August 23, 2016

**Re: 70 Anderson Street - Design Revisions**

NORTH EAST ELEVATION VIEW - BUILDING B

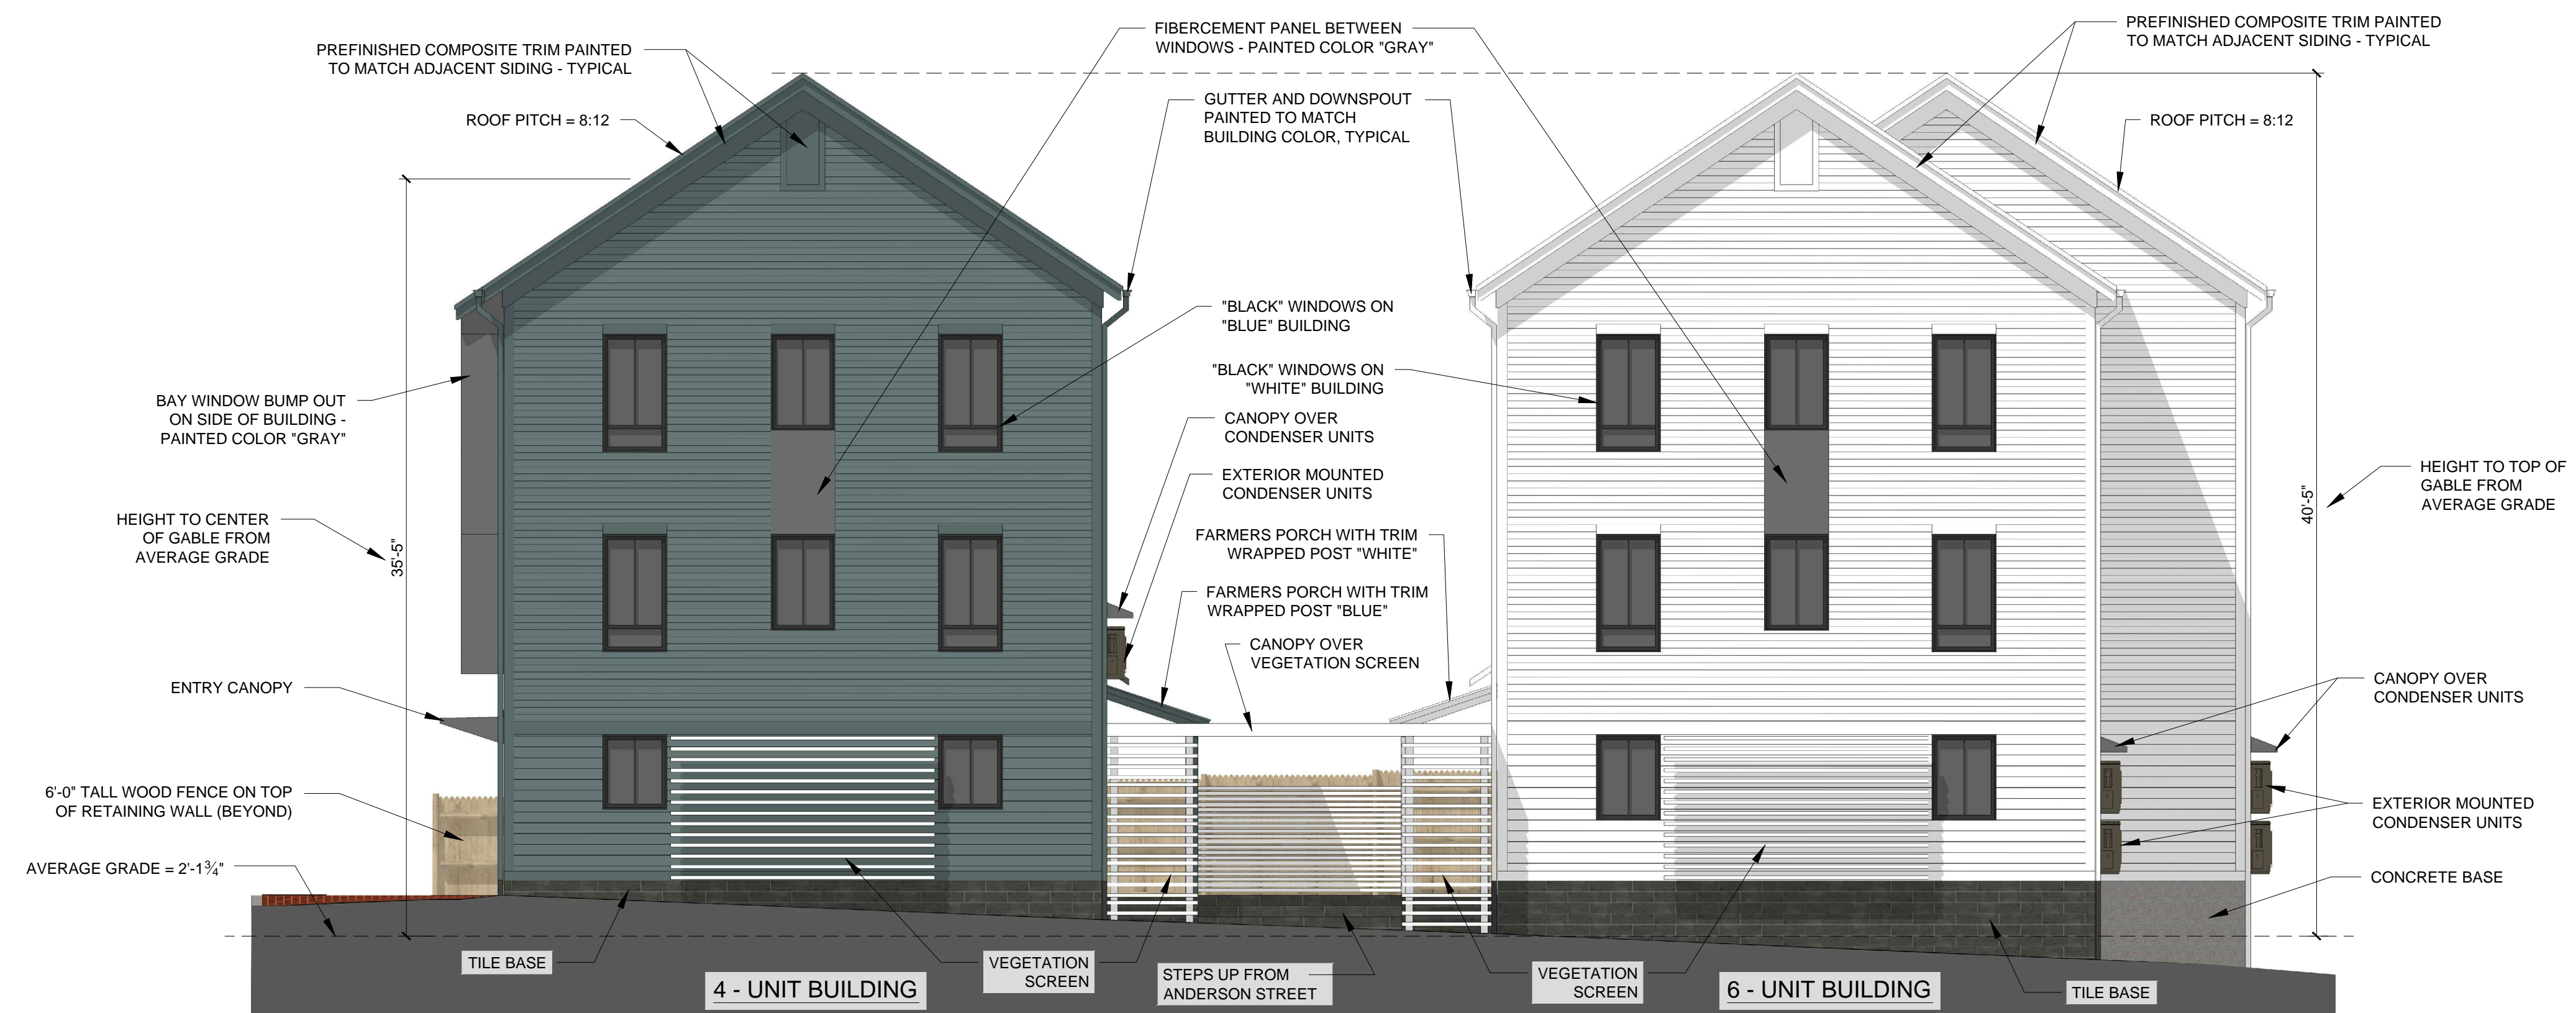
- 1.) We have raised the first floor elevation 12" to provide a raised base relationship that was requested.
- 2.) A base cladding material has been added to the buildings to further emphasize the buildings base and its relationship to the pedestrian level.

- 3.) The sills of the first floor windows adjacent to the streets have been raised to provide privacy to the units from the street.
- 4.) The gable roof pitch has been increased to 8:12 giving the buildings a more vertical proportion similar to the other gable roofs in the surrounding neighborhood.

- 5.) A siding color contrast and slight projection at the gable end creates a vertical bay that further enhances the vertical orientation of the gable end facade.

- 6.) We have added projecting bays to the facades as a means to articulate the facades facing the streets.
- 7.) The buildings color scheme has been simplified which now consists of two major colors, one for each building.
